29 June 2010

7 – 9 GIBBONS STREET, REDFERN
BUILDING CODE OF AUSTRALIA ADVICE – NATURAL LIGHT

02 LEVELS 4-8 RESIDENTIAL FLOOR PLAN
 1:200
 L4 - RL 45.50
 L5 - RL 49.00
 L6 - RL 52.50
 L7 - RL 56.00
 L8 - RL 59.50

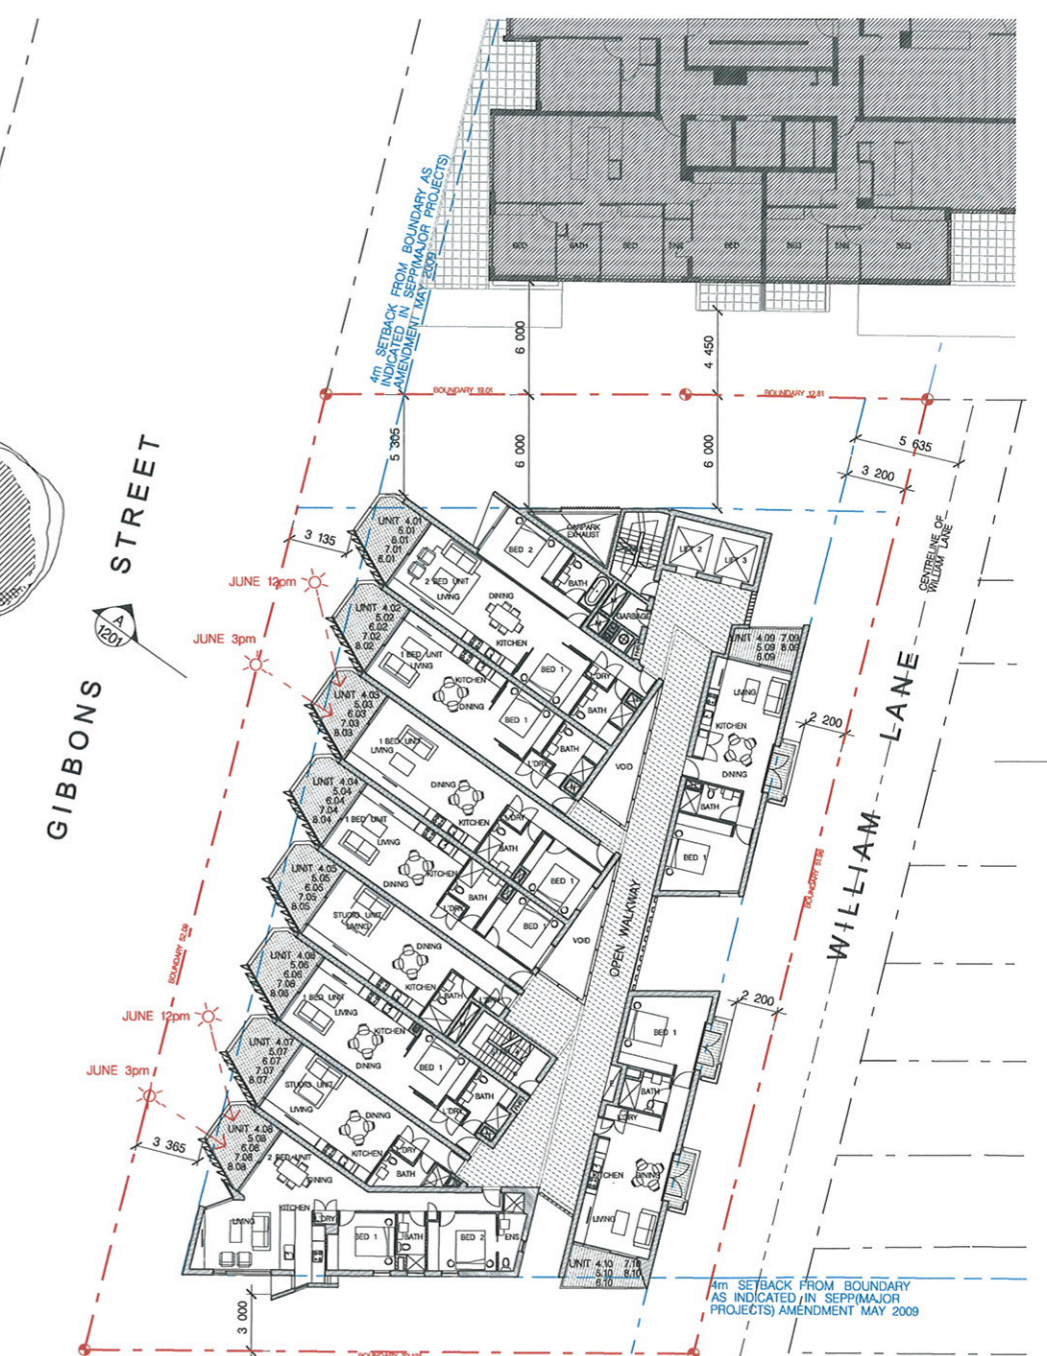
Units 3 & 4 are single bedroom units which are typical over level 4 to 17. Each unit has single bedroom with windows in the external facade of the building facing towards William Lane to the east. The subject windows open toward a void and an external balcony walkway that is partly enclosed by separate units located in the north east & south east corners of the building.

Bed 1's have a floor area of 14.3 m² and 13.1 m² and are therefore required to have windows of unobstructed glazing of not less than 1.4 m² and 1.3 m². The light transmitting area of each window has been calculated as being at least 2.6 m² each. On this basis compliance with F2.4 is achieved.

However, due to the balcony being enclosed for the majority of its length, except the portion adjacent to the subject units, it is considered appropriate to consider compliance under the borrowed light requirements for F4.3 as a conservative assessment. The total area of the bedrooms, void space and balcony adjacent to the external wall of the bedrooms is 48.2 m². We have assumed that the opening of the balcony is 50% reduced by the screening and therefore has an unobscured area of 5.12m² which exceeds the 10% requirement. On this basis compliance with F4.3 would also be achieved.
